FLYING HORSE NORTH

SKETCH PLAN SUBMITTAL

Letter of Intent

August 18, 2022

FLYING HORSE NORTH SKETCH PLAN
SKETCH PLAN DRAWING

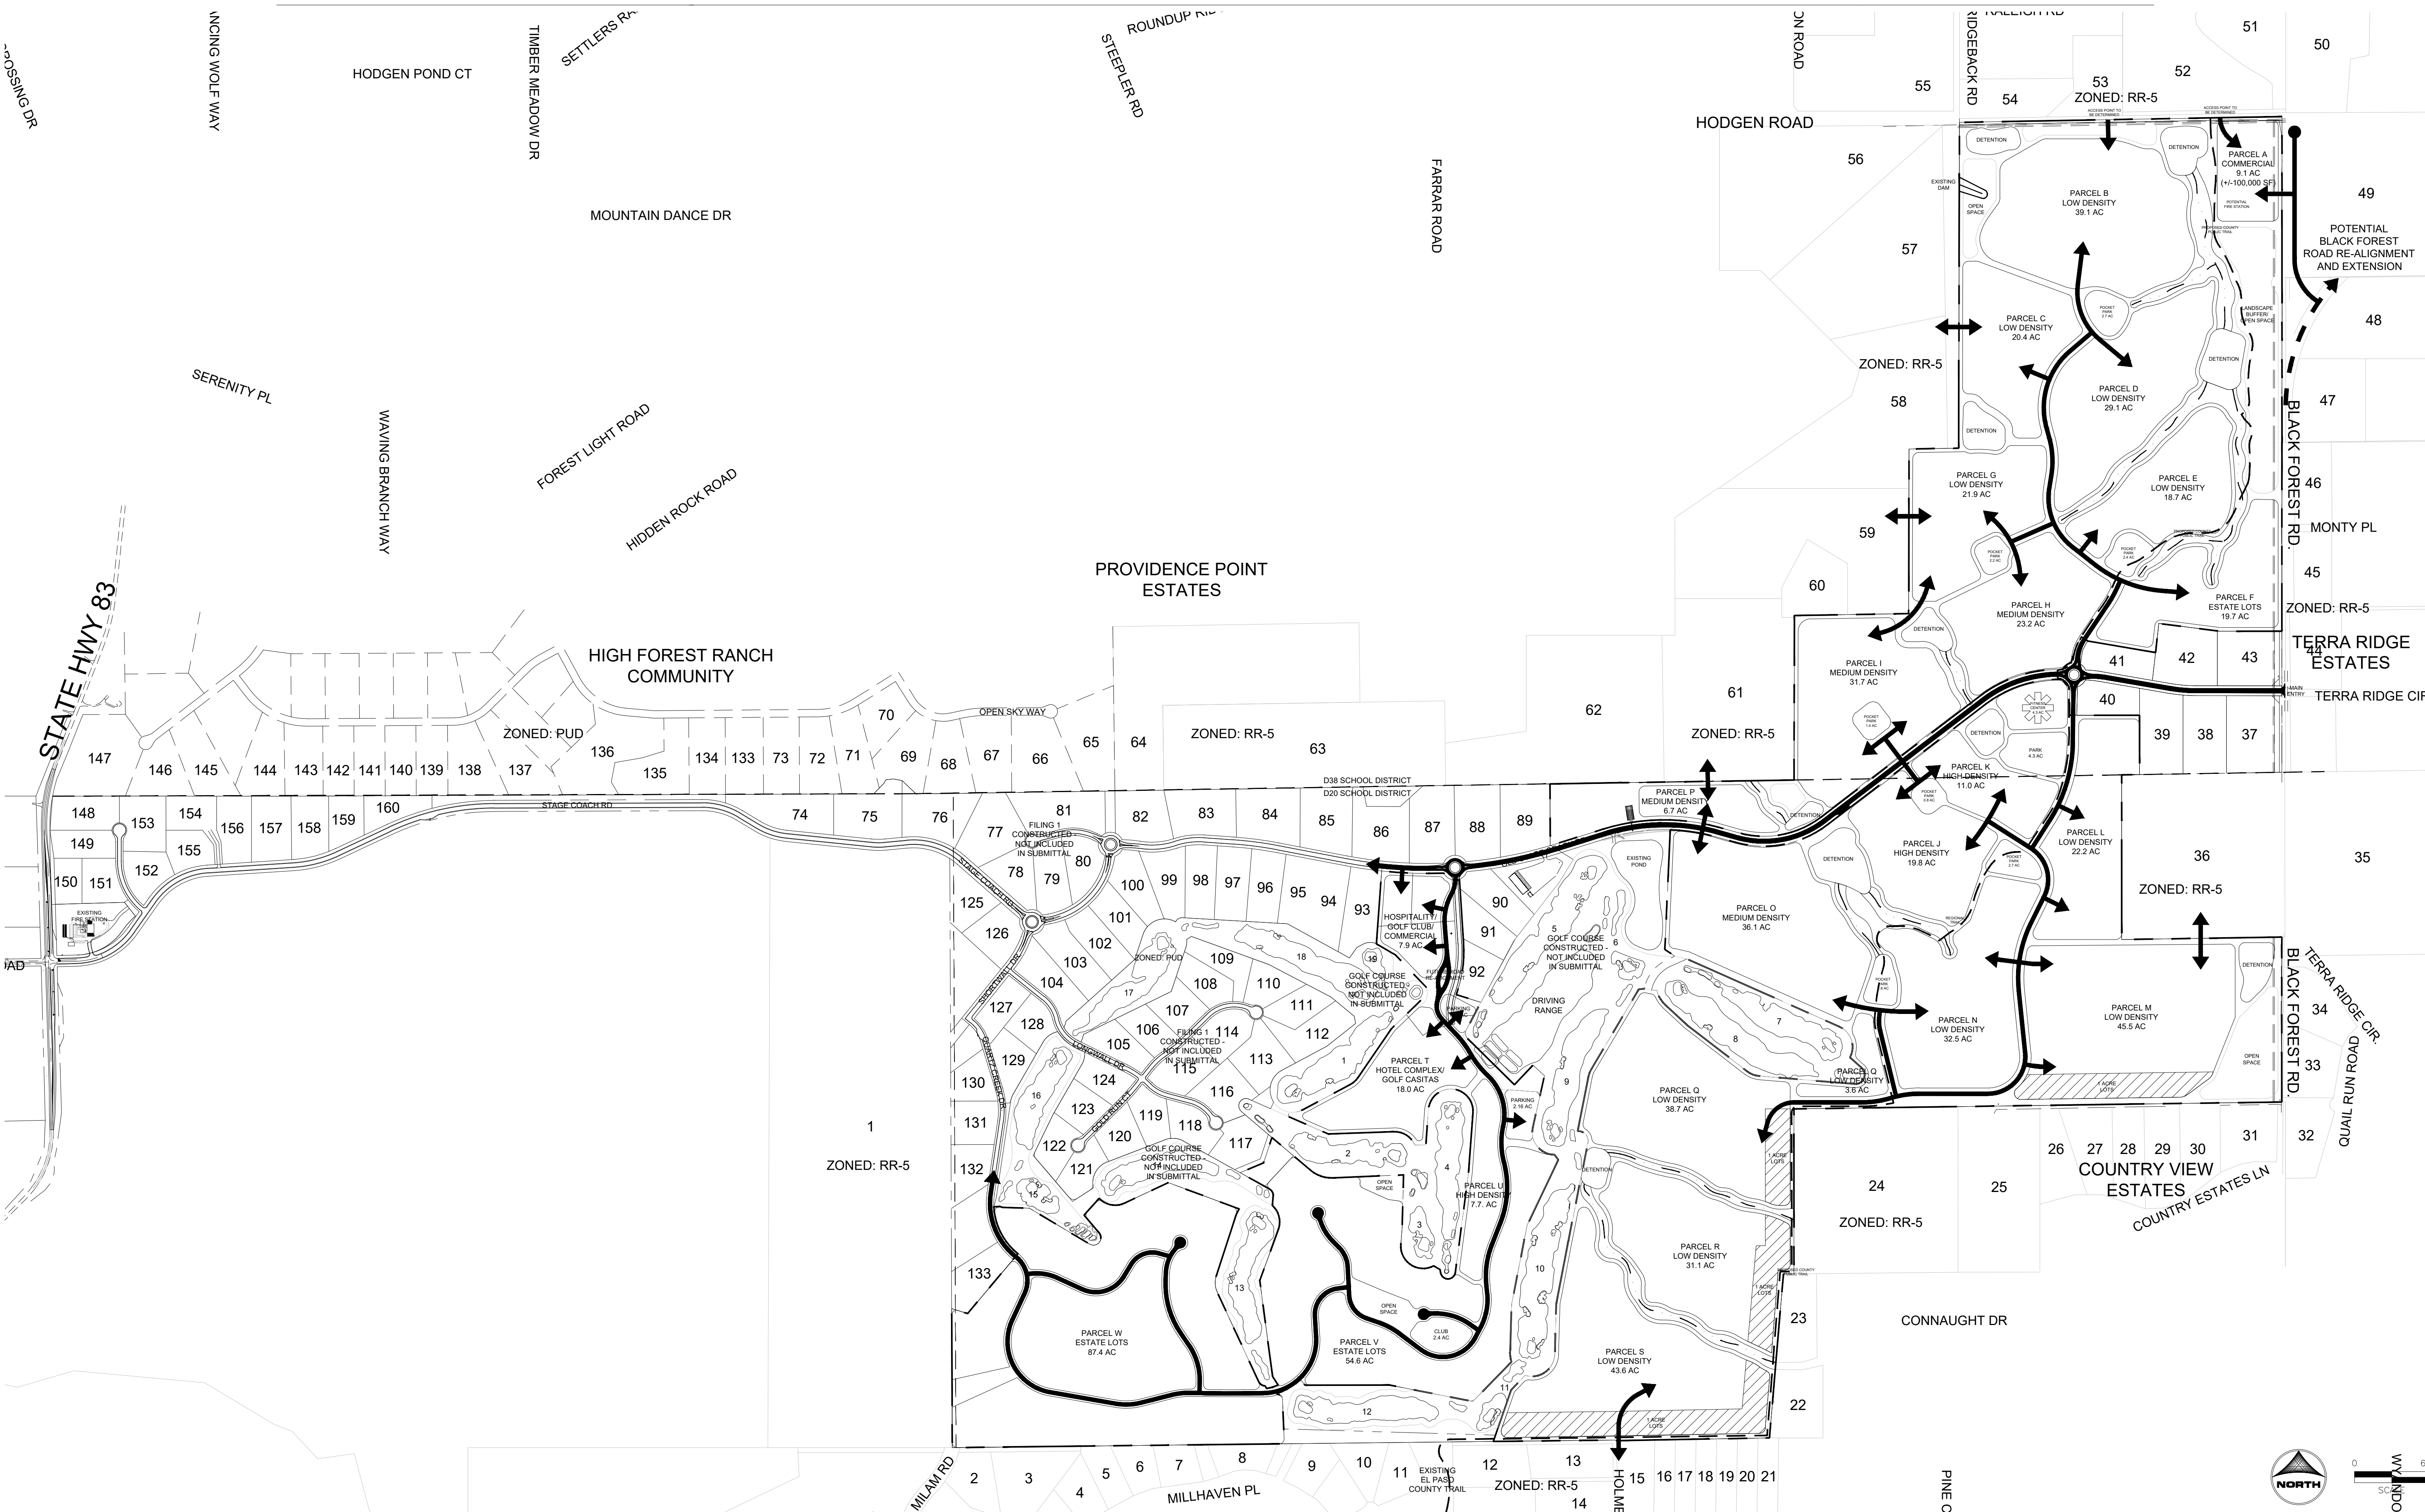
This would be a good place to include the current entitlements and explain the net increase in density and number of lots from current approvals.
